Arborist Memo

TO: Sean and Lori Kell
CC: Anne James Landscape Architects
SITE: 7450 N Mercer Way, Mercer Island
RE: Tree Inventory
DATE: December 21, 2018
PROJECT ARBORIST: Holly Iosso, Registered Consulting Arborist # 567
ISA Certified Arborist #PN-6298A
ISA Qualified Tree Risk Assessor
Tyler Bunton
ISA Certified Arborist #PN-8715A
ATTACHED: Table of Trees
Tree Inventory Site Plan

Based on the landscape plan by Anne James dated November 26, 2018, I have the following observations and recommendations:

Tree Inventory, Protection  
and Removals Plan

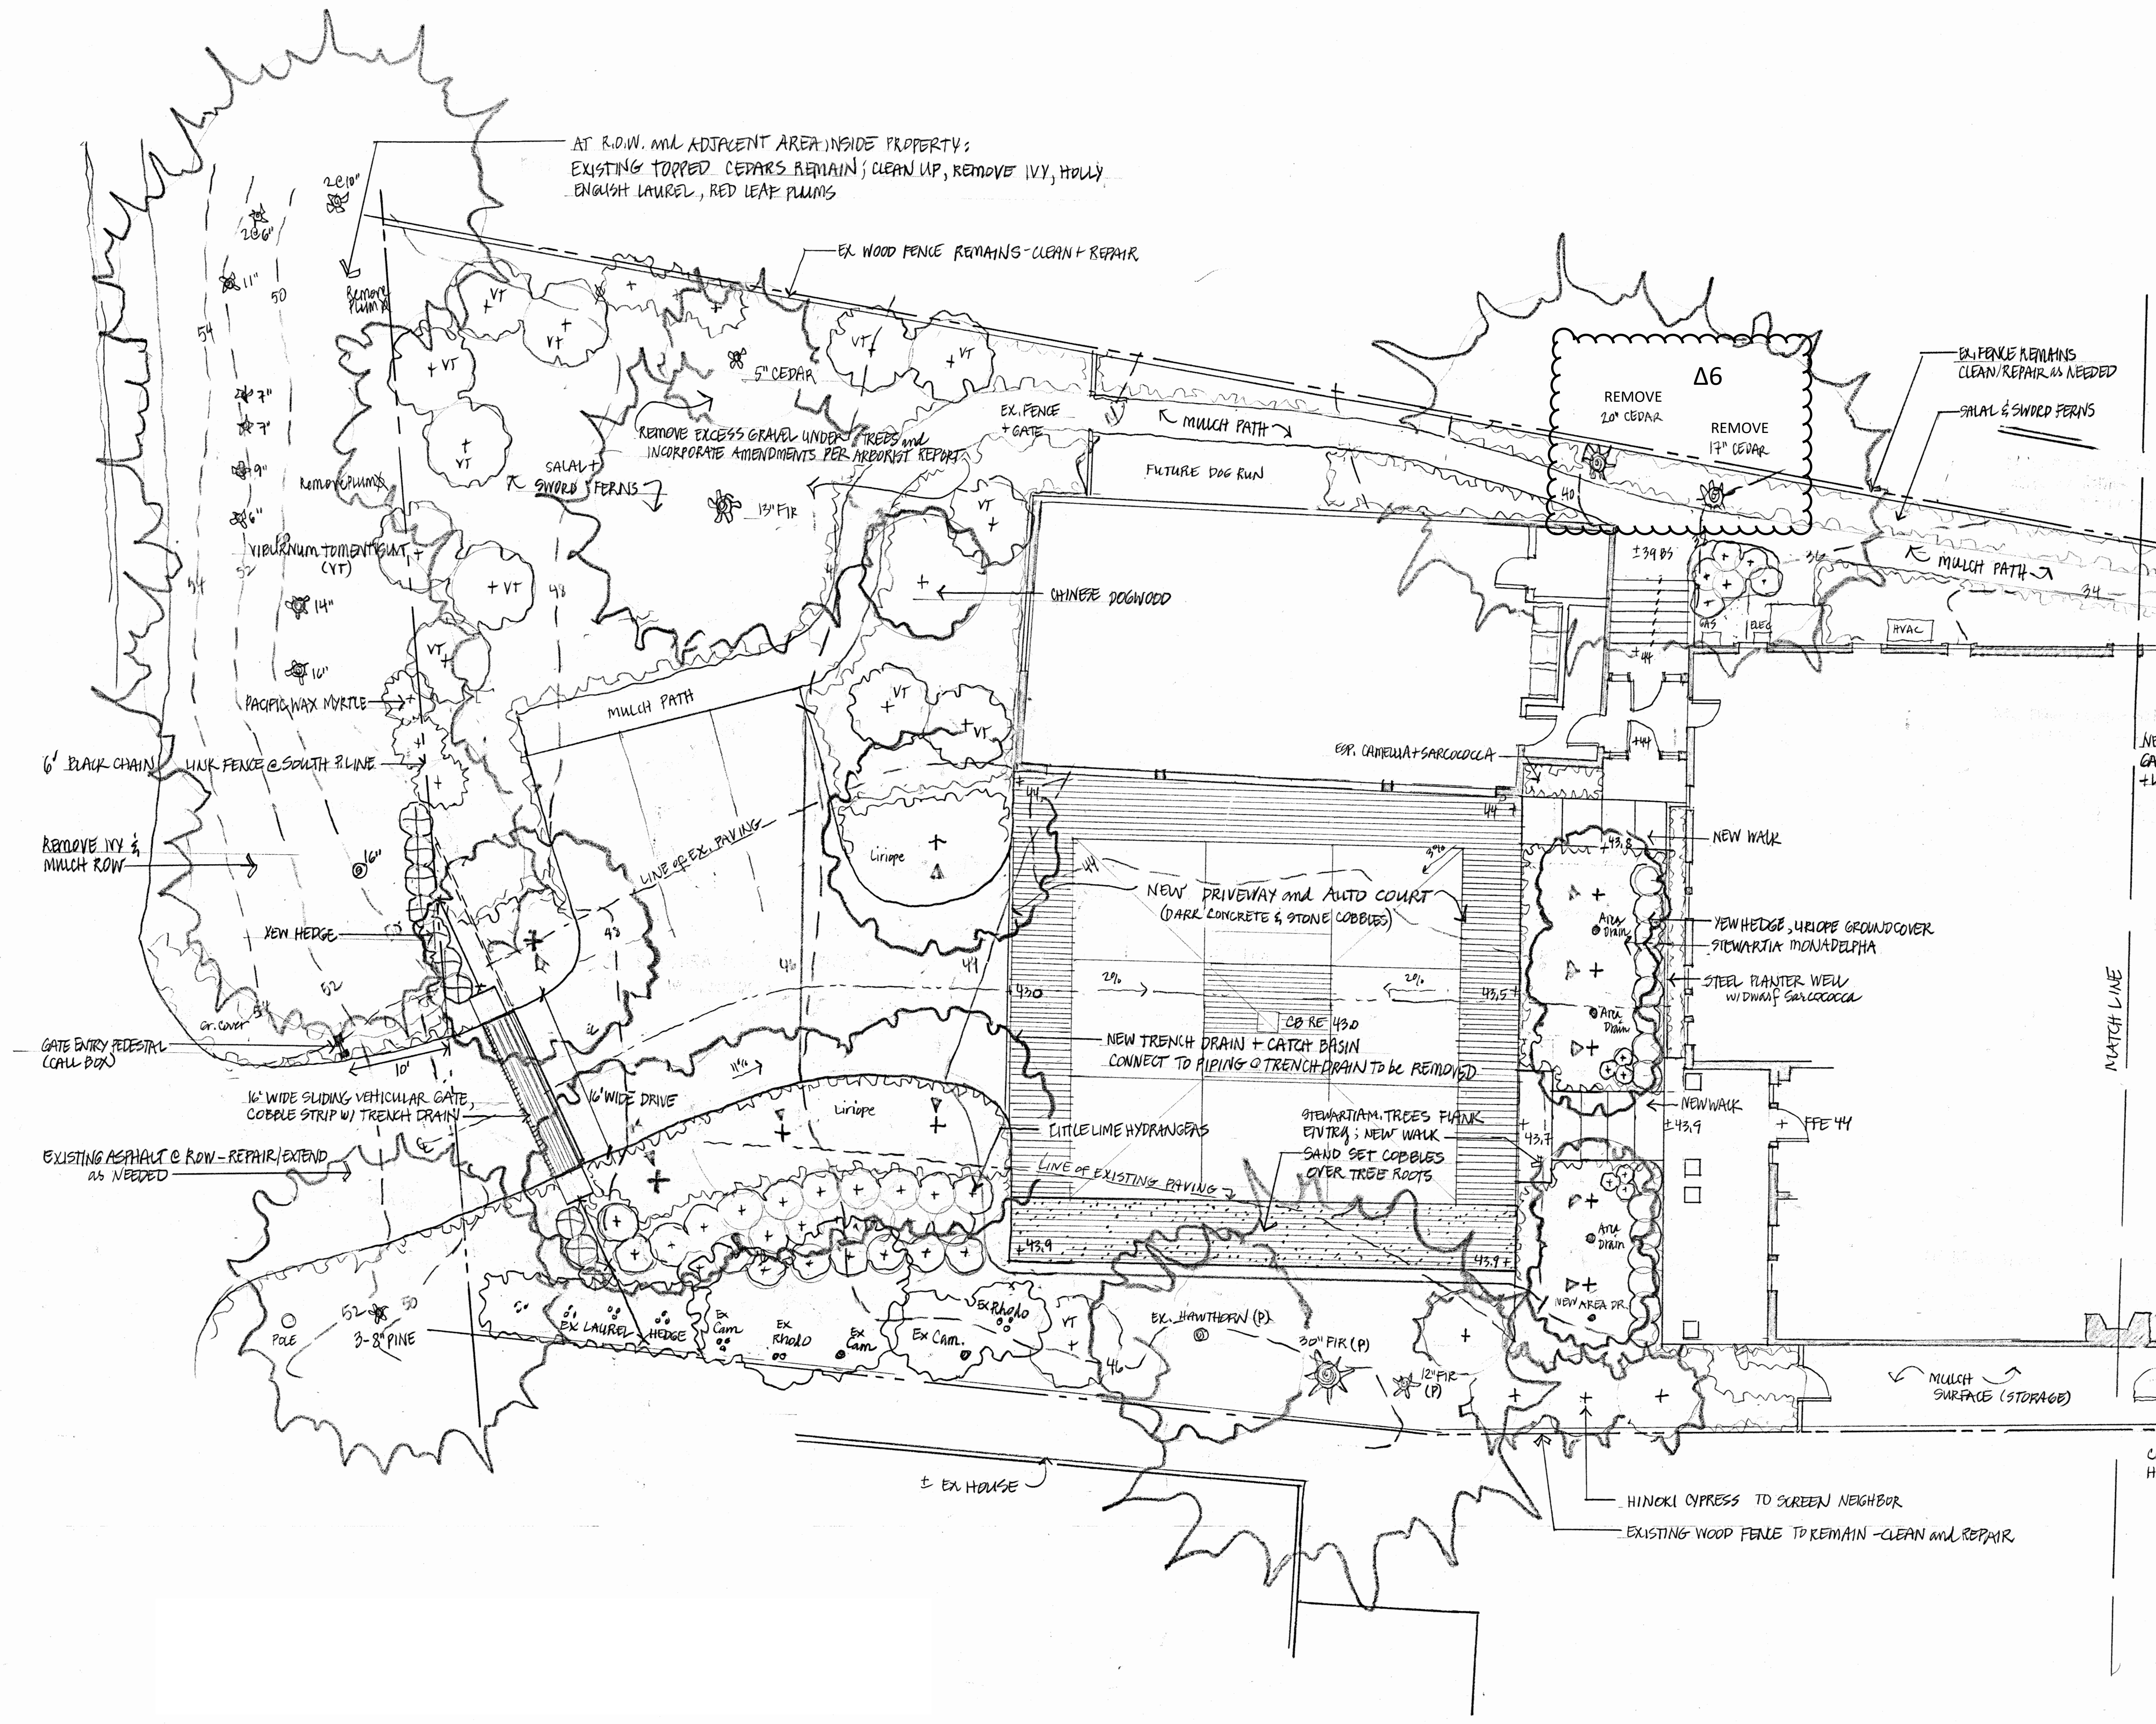
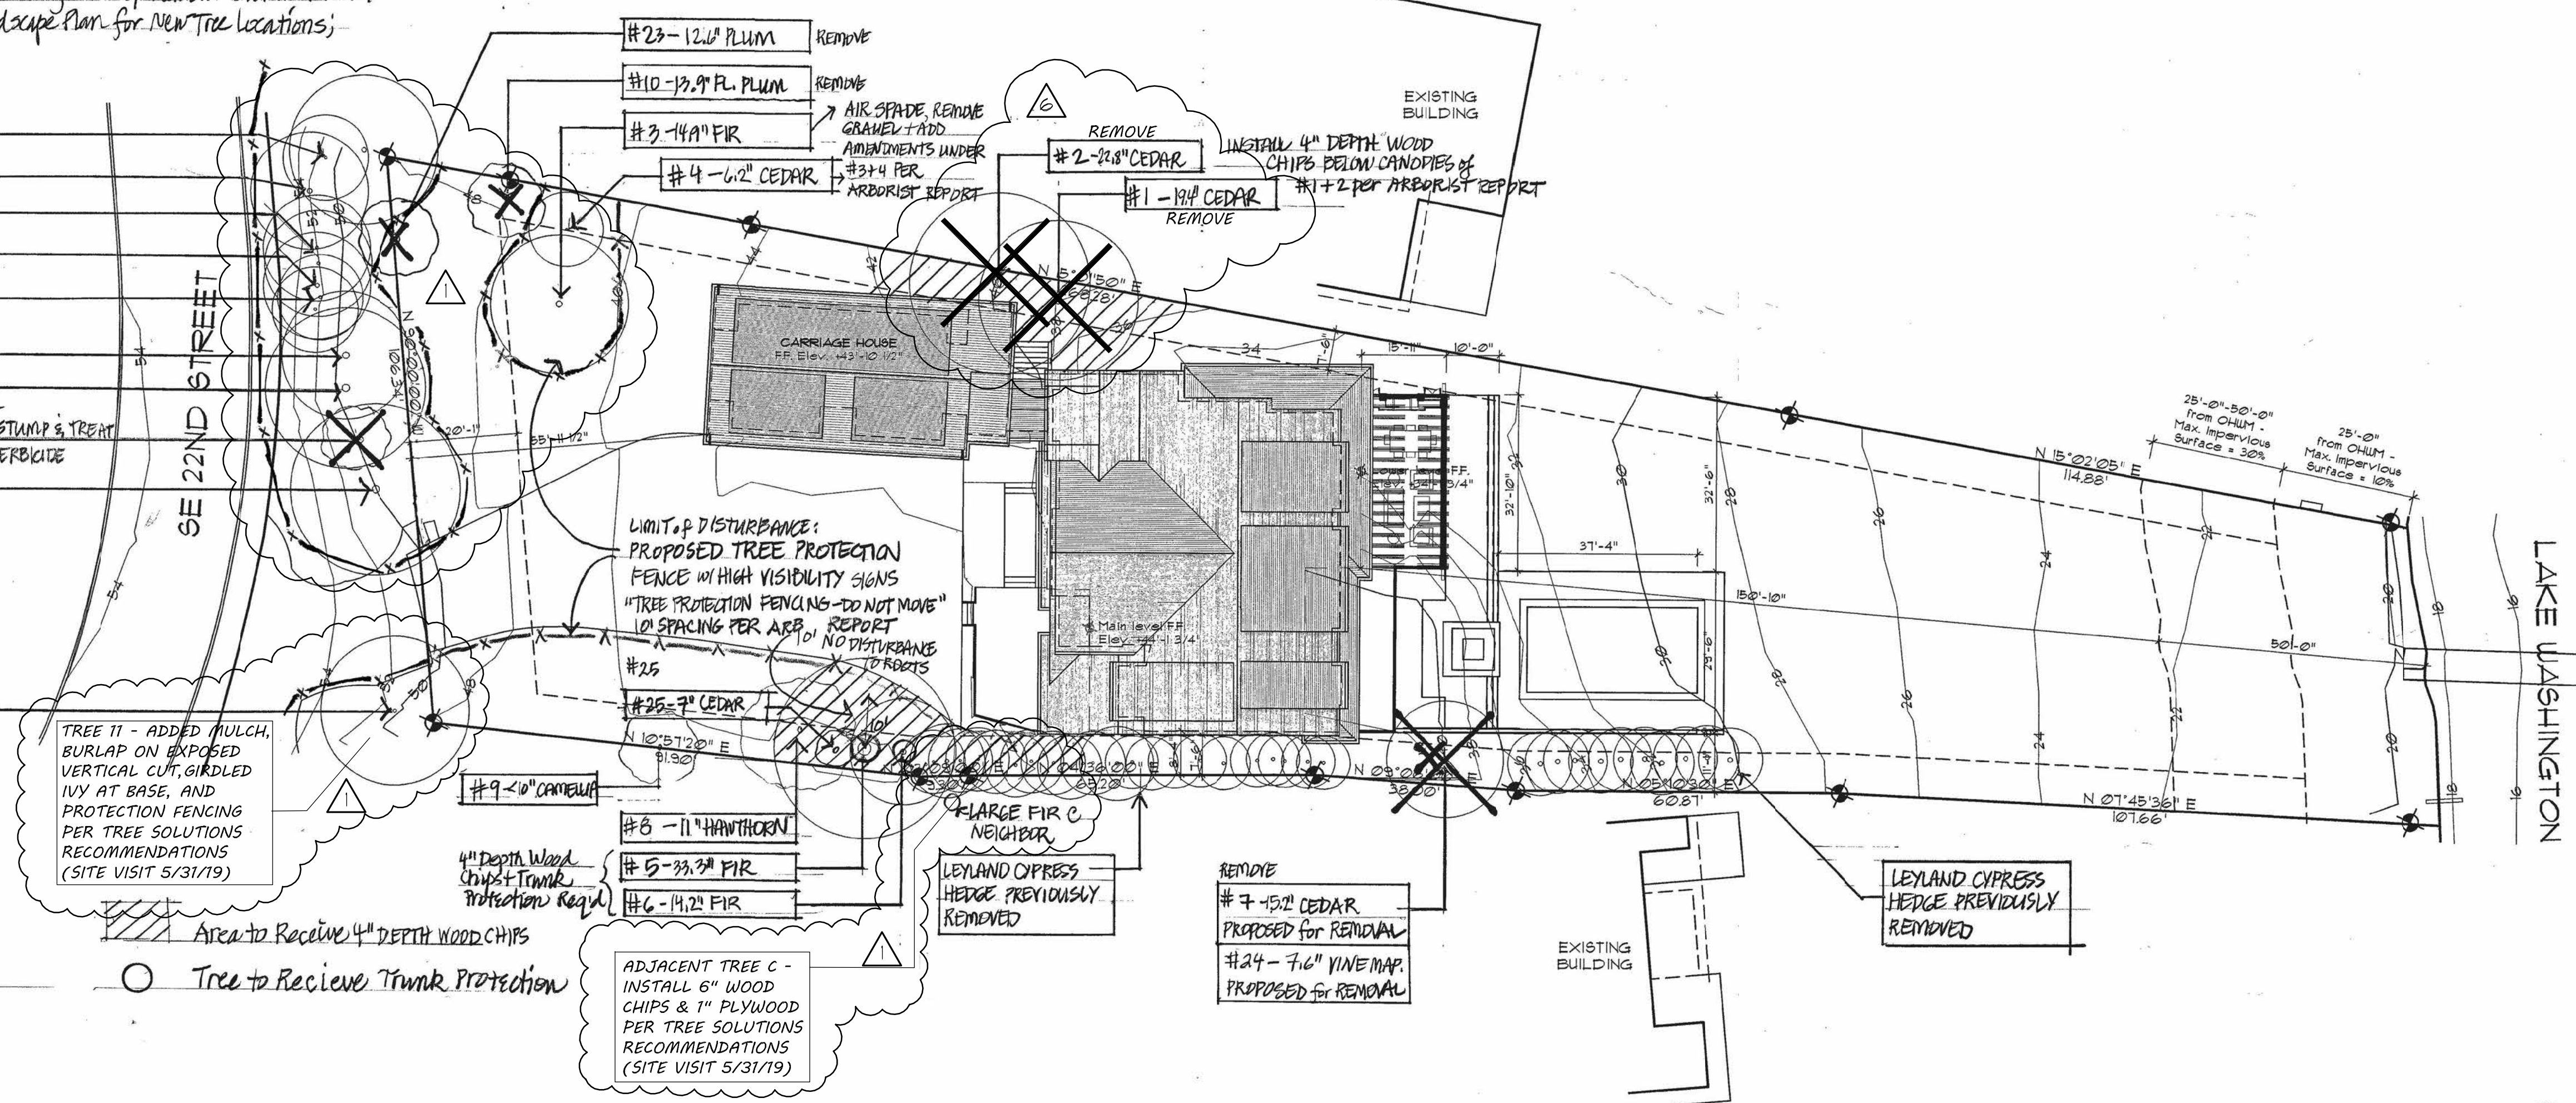
Trees 7 and 24 are proposed for removal within the 200-foot shoreline buffer. Neither are exceptional.

Trees 3, 4, 10, and 23 are buried from growing in a previously compacted parking area with gravel. Some fibrous roots have grown up through this gravel layer. I recommend decompaction of the area with an air-knife or equivalent. This tool can help remove the gravel where possible using hand methods, following with an incorporation of sandy loam topsoil and/or organic matter such as compost through the area.

Tree 5 may be impacted if driveway is redesigned. Recommendations to reduce impacts include:

Trees 1 and 2 are surrounded by bare ground and have had crown raising in the past. Surface erosion is likely in this area unless mulch (ideally arborist wood chips) are installed 3-4 inches deep.

One English holly (*Ilex aquifolium*) shrub is proposed for removal within the city ROW. The stump should not be pulled because it will damage adjacent tree roots. Stump can be treated with herbicide to reduce the likelihood that new sprouts will grow back after tree is removed.

- No tree roots should be severed within 10 feet of the root flare of the tree.
- Establish tree protection at limits of driveway. Delay moving tree protection in to new location of driveway until time to set forms for concrete.
- Temporary ground protection should be in place if tree protection is not placed at the limits of the concrete driveway, or the driveway is removed. This includes 4-6" of arborist wood chips below ½ inch plywood.
- During excavation for new driveway, field inspection should drive deviation from specifications and not cut roots where possible.

- Additionally, fencing and mulch should be installed immediately to protect trees 1 and 2 and minimize runoff and compaction from winter rains
- All offsite trees, including right of way trees, must be protected during construction.
